An
Bord
Pleanála

Board Order ABP-314610-22

Proposed Development: Construction of the Ballymun/Finglas to City Centre Core Bus Corridor Scheme, which has an overall length of approximately 10.9 kilometers, comprising:

Programme Title: BUSCONNECTS DUBLIN CORE BUS CORRIDORS INFRASTRUCTURE WORKS			
Drawing Title: BALLYMUN / FINGLAS TO CITY CENTRE CORE BUS CORRIDOR SCHEME FENCING & BOUNDARY TREATMENT			
Drawing File Name: BCIDD-ROT-SPW_BW-0304_XX_00-DR-CR-0017	Sheet Number: 17 of 37	Status: A	Rev: M01

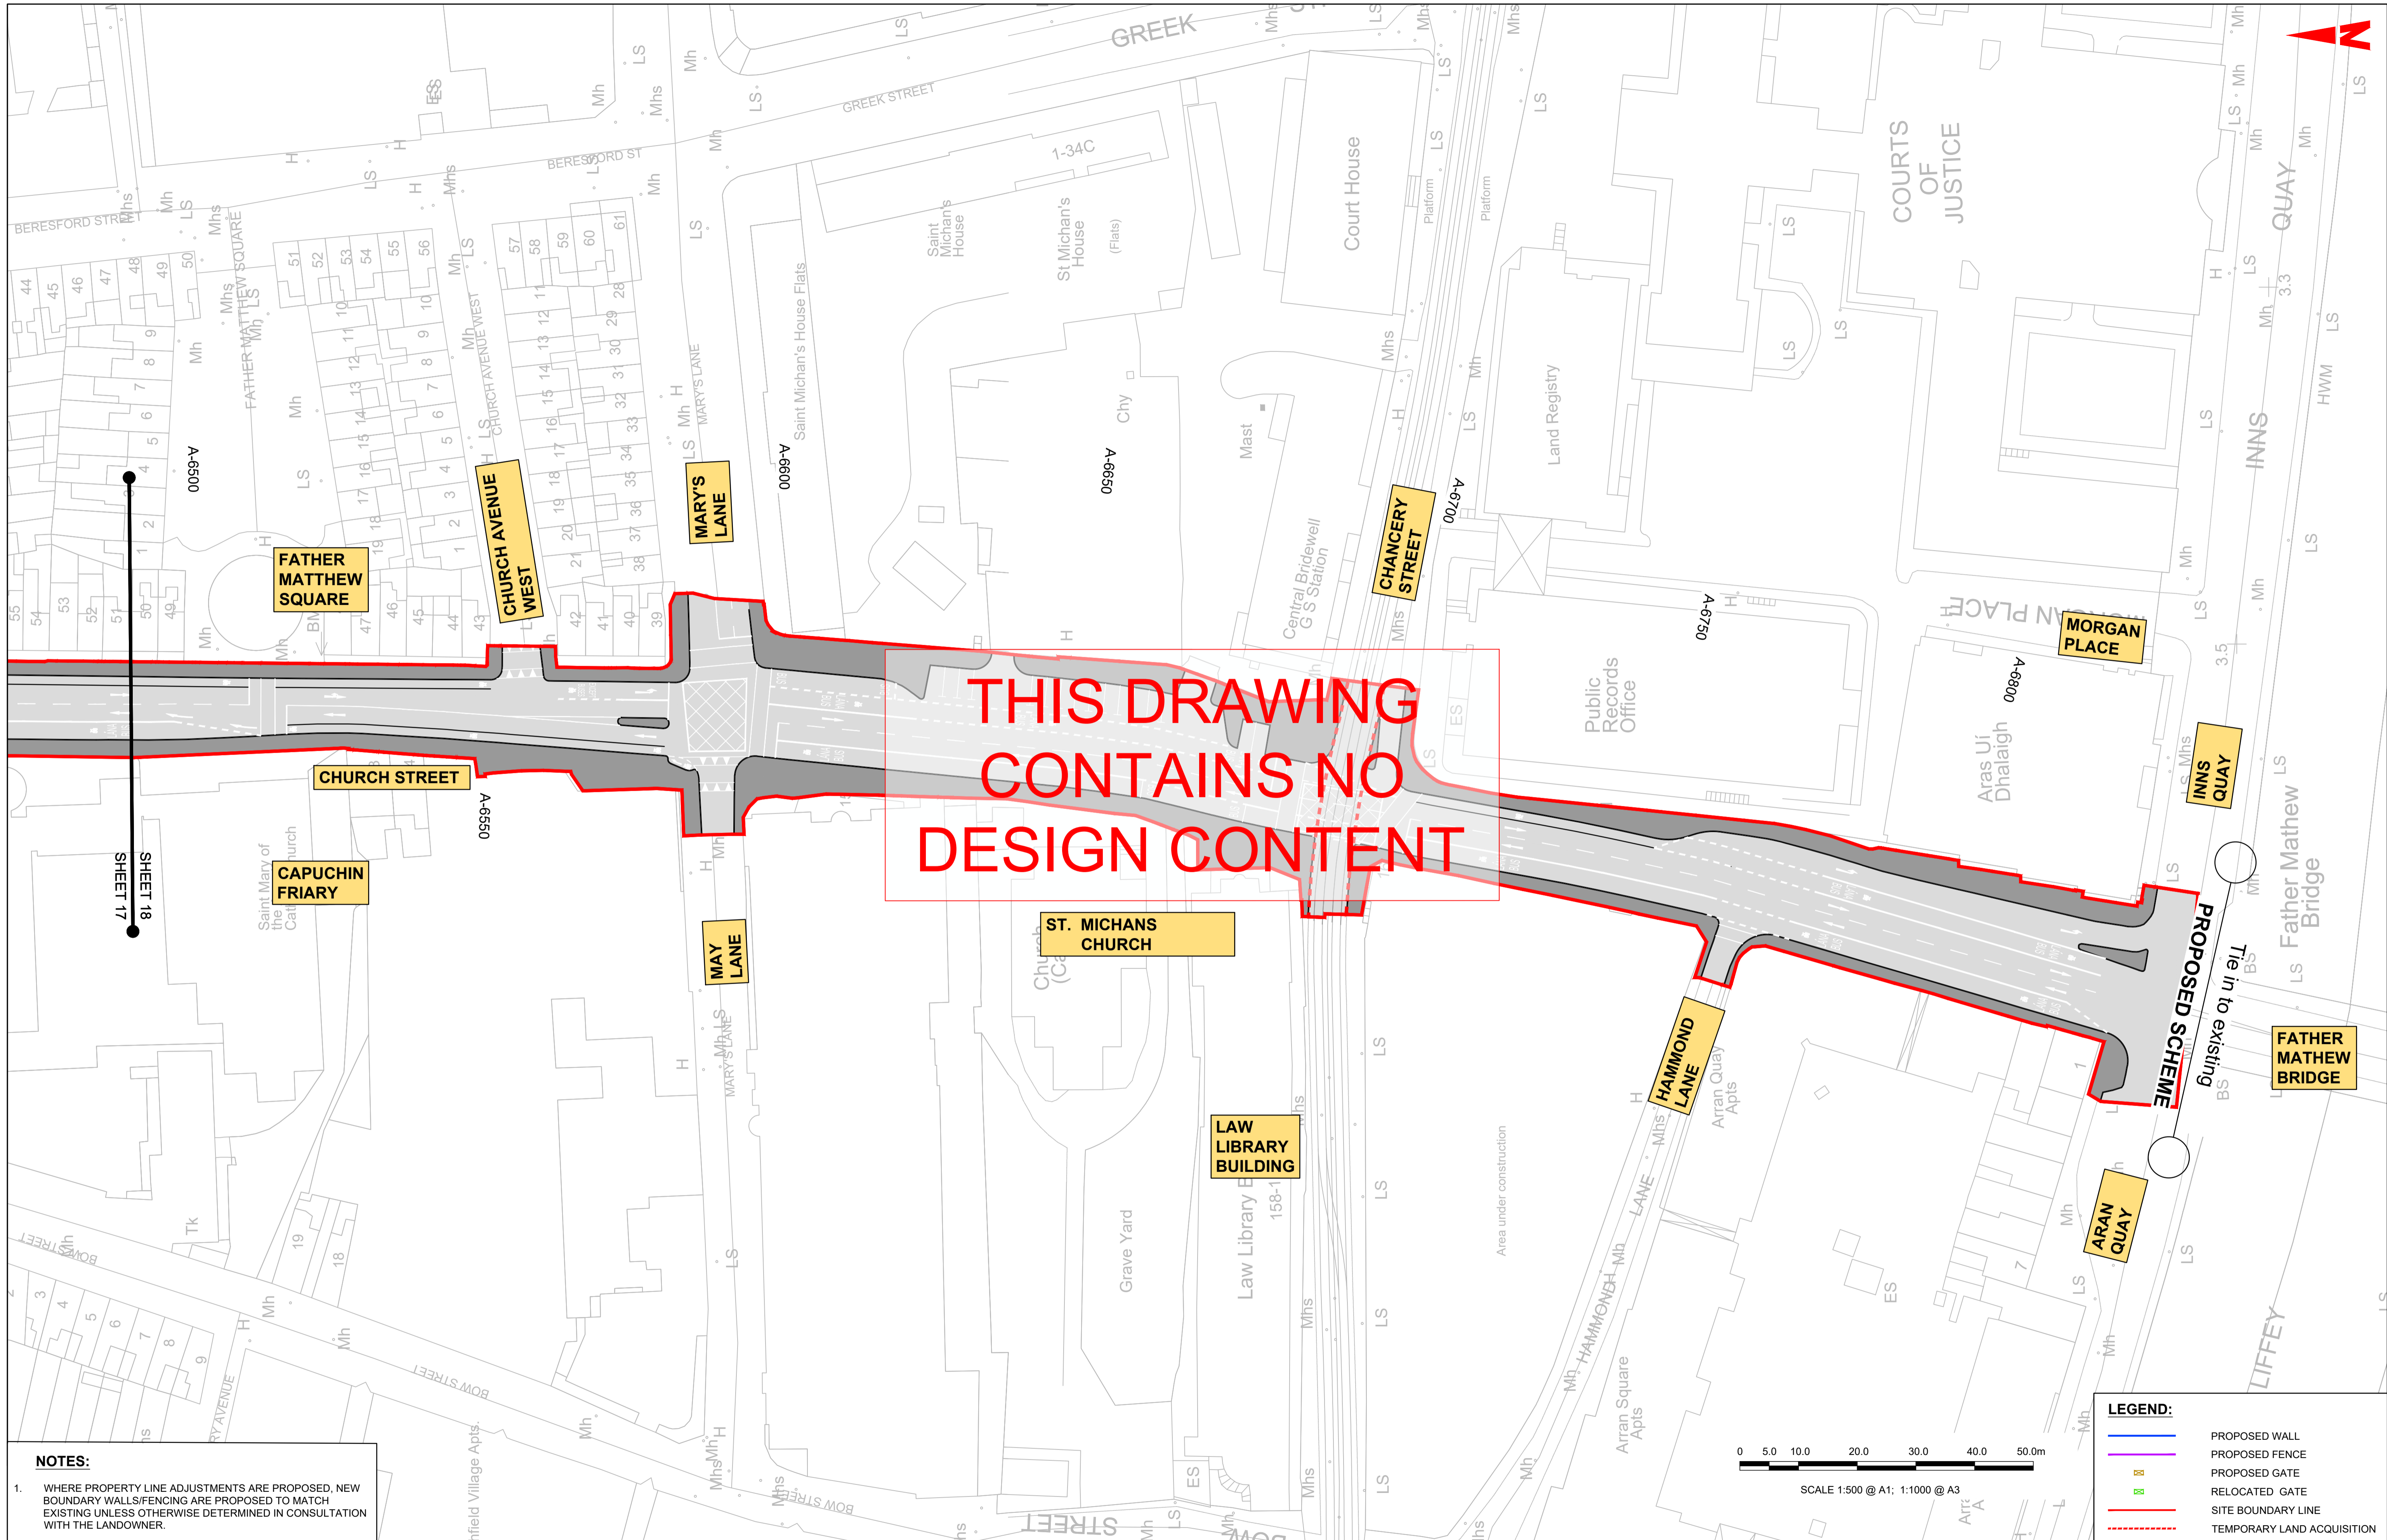
7. Prior to the commencement of development, the location and duration of use of the proposed construction compound at Catherine Lane North (shown as temporary land acquisition on General Arrangement Drawing Sheet 17 of 37) shall be agreed with Dublin City Council and the use of this compound shall not conflict or impede the delivery of consented housing at this location.
